2022/0327

Display of various high level illuminated signs on all 3 sides of the cinema building and above the entrance doors (Amended signage proposals compared with previous advertisement consent reference 2020/1096)

30 The Glass Works, Barnsley, S70 1GW

Drawing No. 1722\BA-019 Revision M

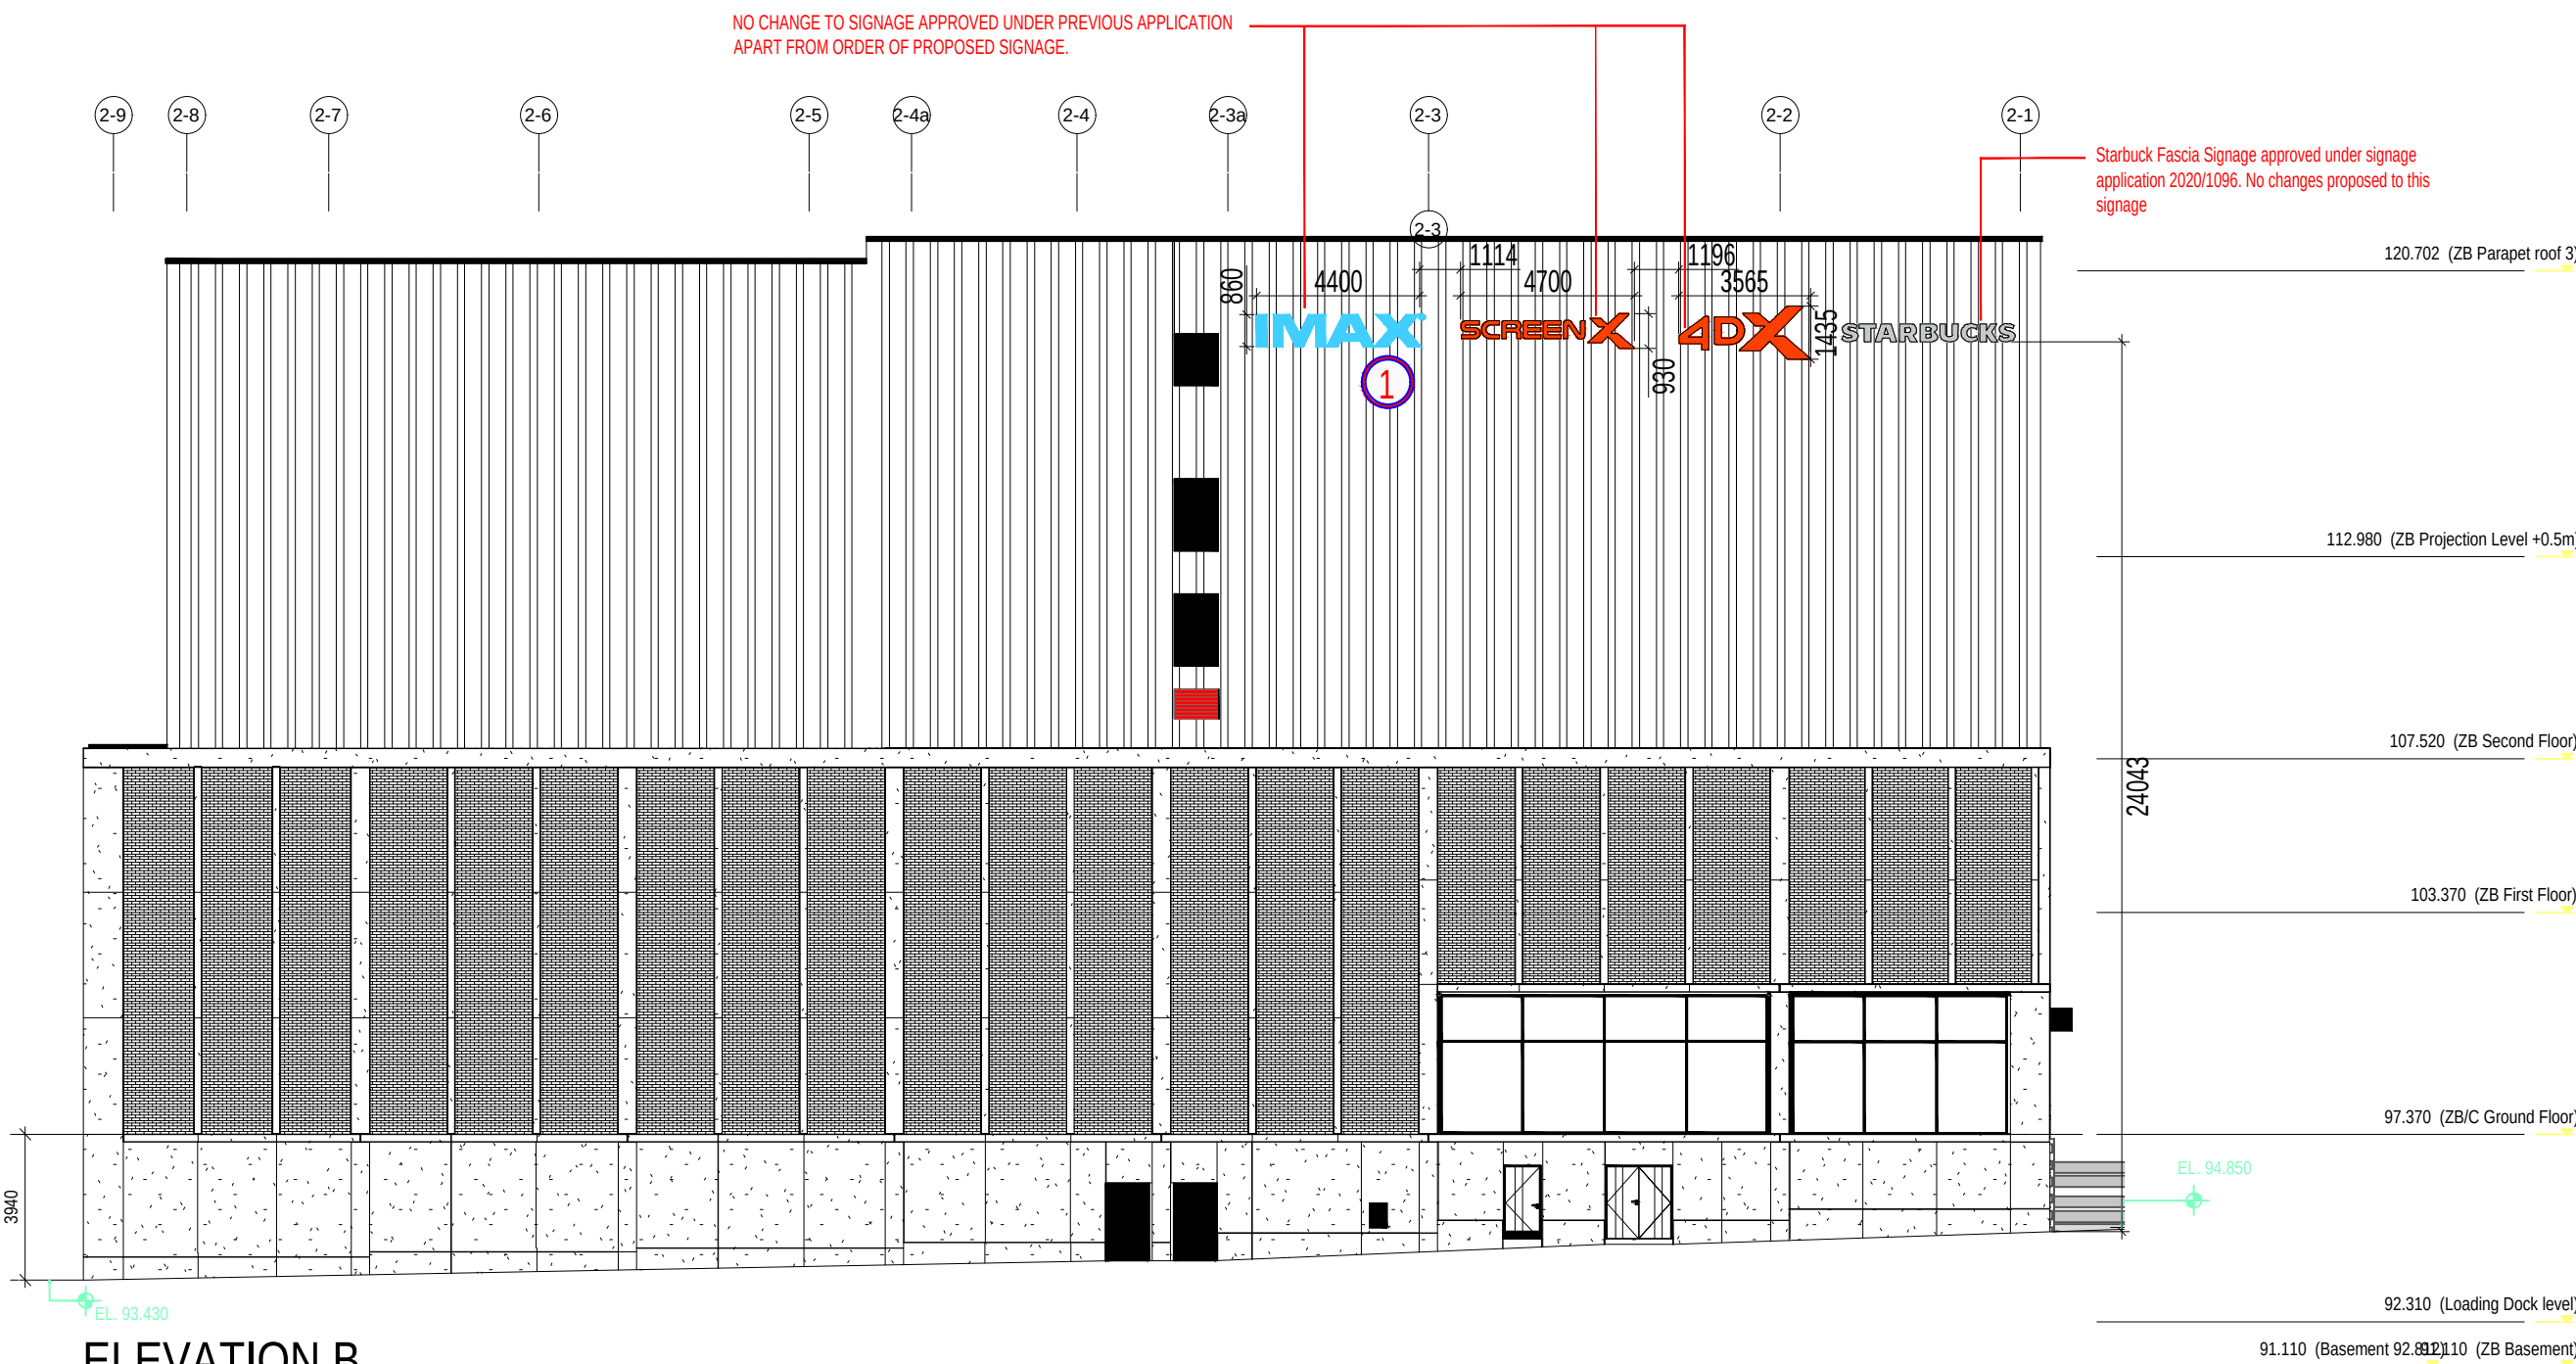
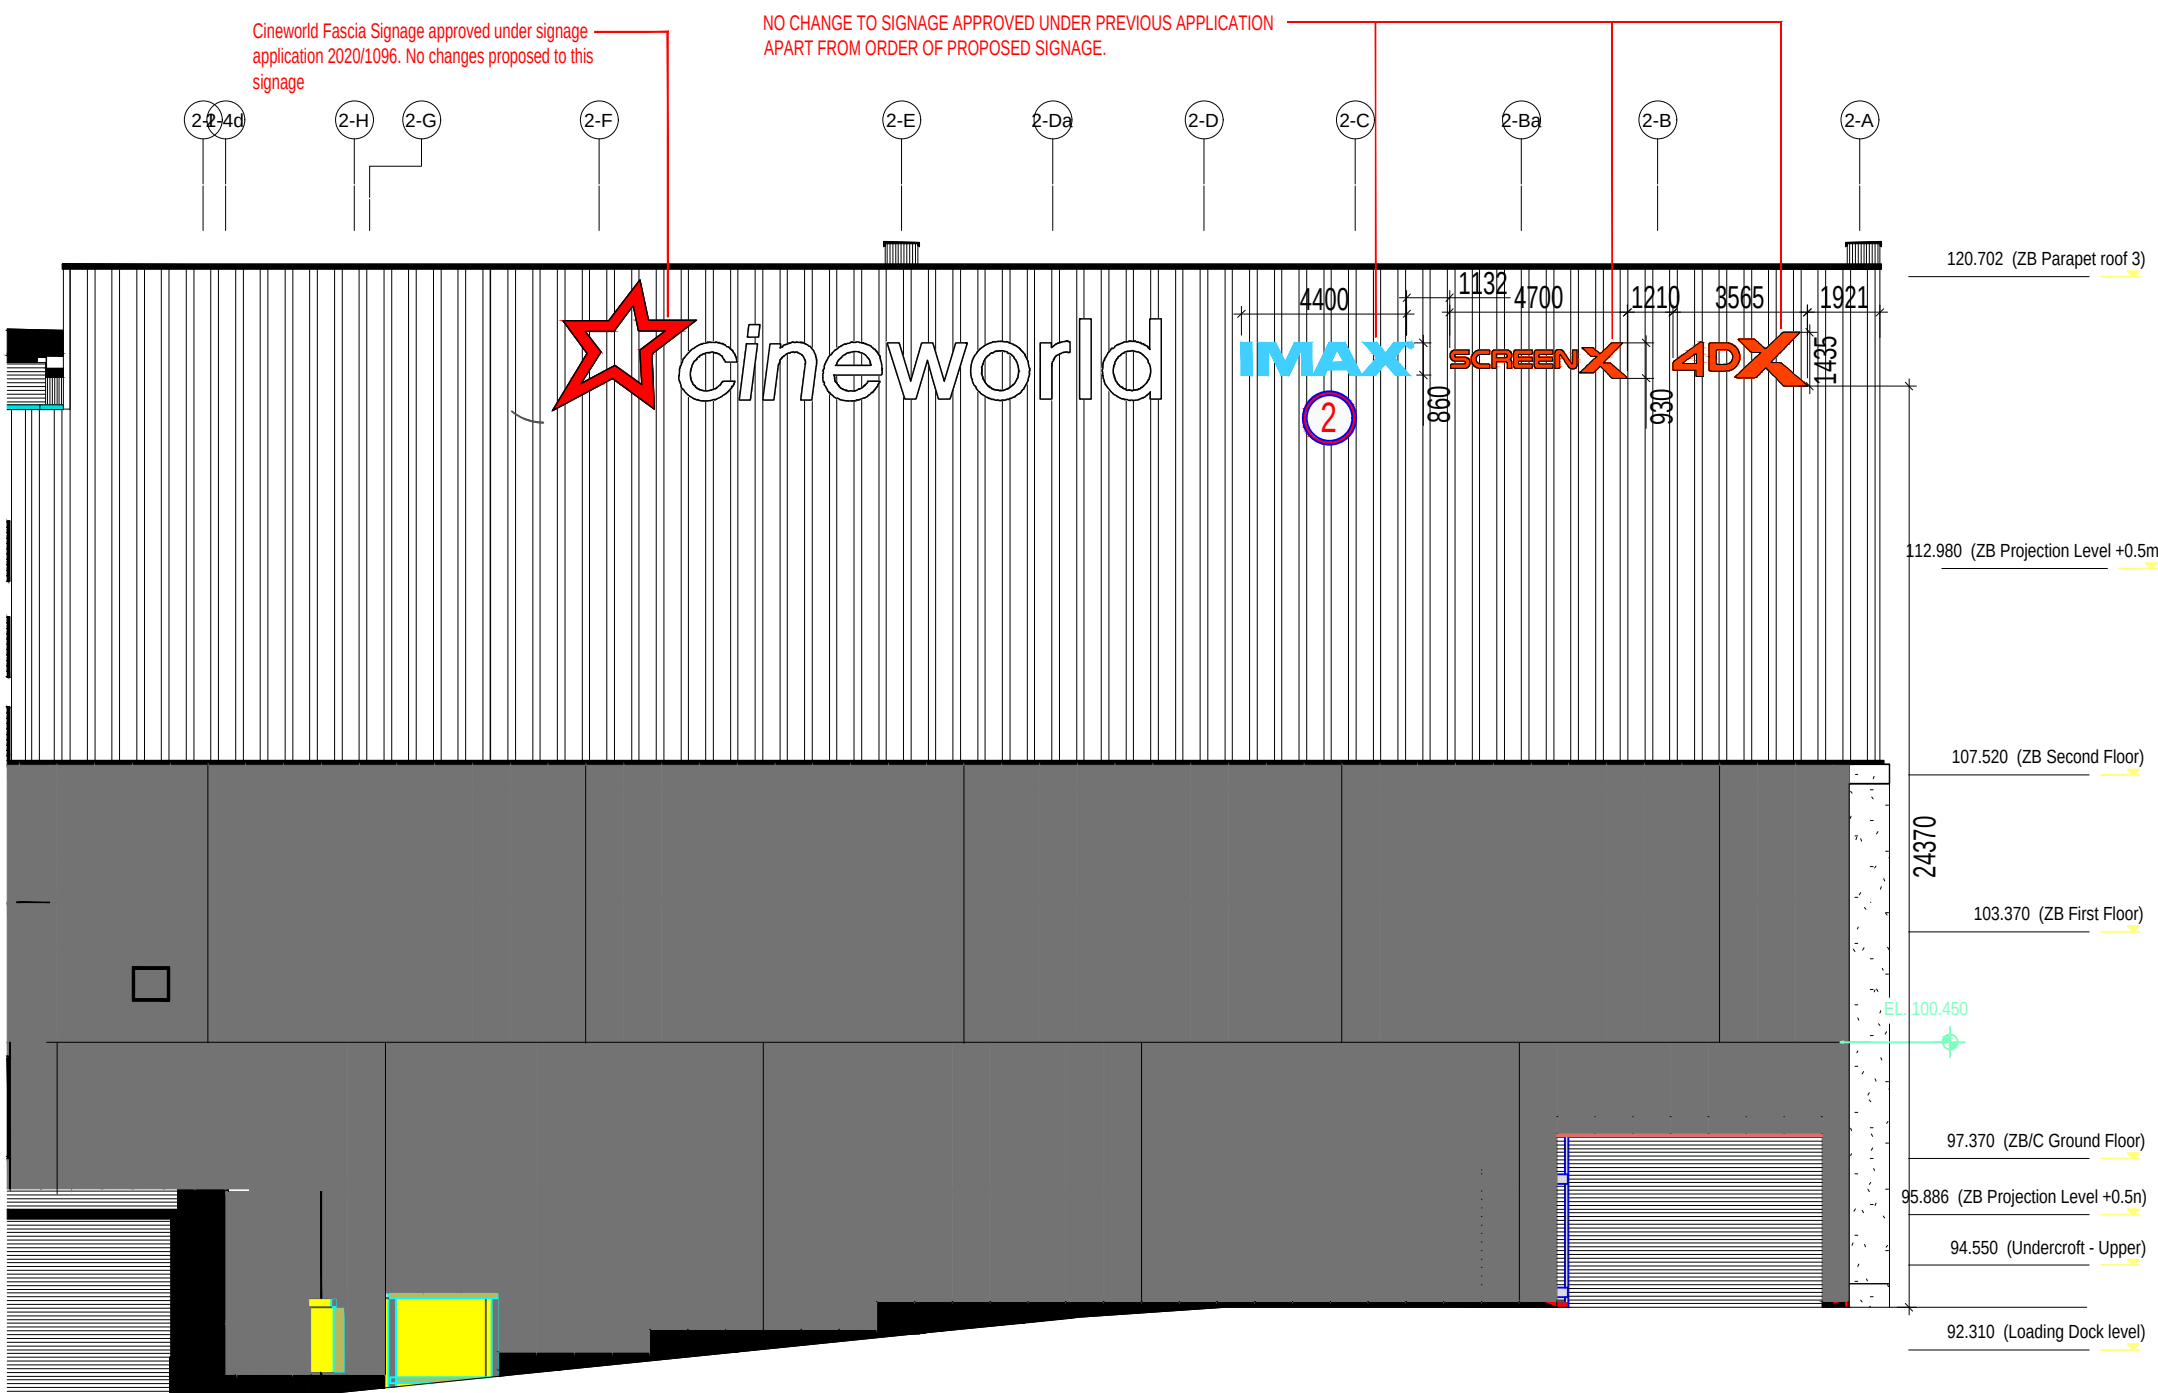
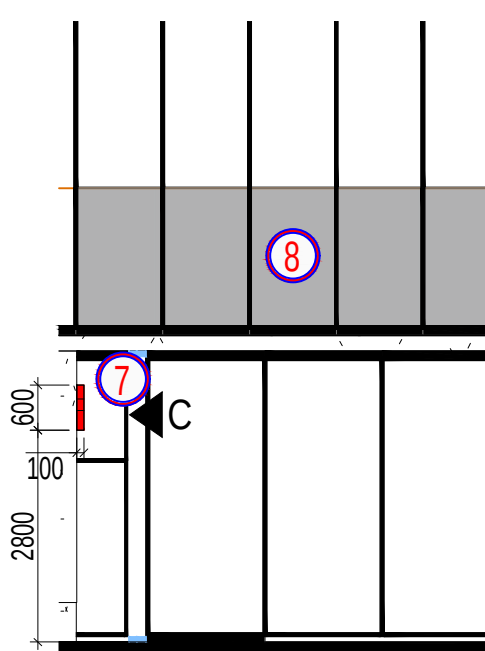
1. Proposed signage order altered - approved signage order SCREEN X, 4DX, IMAX. Proposed order IMAX, SCREEN X, 4DX
2. Proposed signage order altered - approved signage order SCREEN X, 4DX, IMAX, STARBUCKS. Proposed order IMAX, SCREEN X, 4DX, STARBUCKS.

3. Cineworld signage previously approved as internally hung behind glazing, New proposal is for the the signage to be externally mounted on steel rails directly in front of the mullions, rails to be powder coated to match existing mullion colour. Please refer to Section B for further information.

4. SCREEN X , 4DX & IMAX signage previously approved as internally hung behind glazing, New proposal is for the the signage to be externally to existing fixing points in the external mullions. Signage to be hung as per detail in Section B.

5. STARBUCKS signage previously approved as internally hung behind glazing, New proposal is for the the signage to be externally mounted on existing fixing locations in external mullions. Signage to be hung as per detail in Section B.

6. New Starbucks illuminated projecting signage to be installed on column.
7. New illuminated Cineworld Star to be mounted on external column.
8. Existing vinyl internally applied to hide structure and void to be retained.

9. New starbucks logo illuminated sign - to be internally hung.

- Starbucks logo placement
- Lack of detail about supporting structure of the externally hung signage above the doorways
- LED video mesh
- Vinyl on first floor windows
- Window details
- Detail on how the Starbucks logo will be affixed to the pillar
- Detail on how the red star is affixed directly to the pillar

The agent submitted a revised drawing (ref. 1722/BA-019 Rev. M) and further information in an email (dated 01/08/2022) which provided a response to Urban Design Officer’s comments. The Urban Design Officer removed the objection on the basis of the revised drawings and updated information.
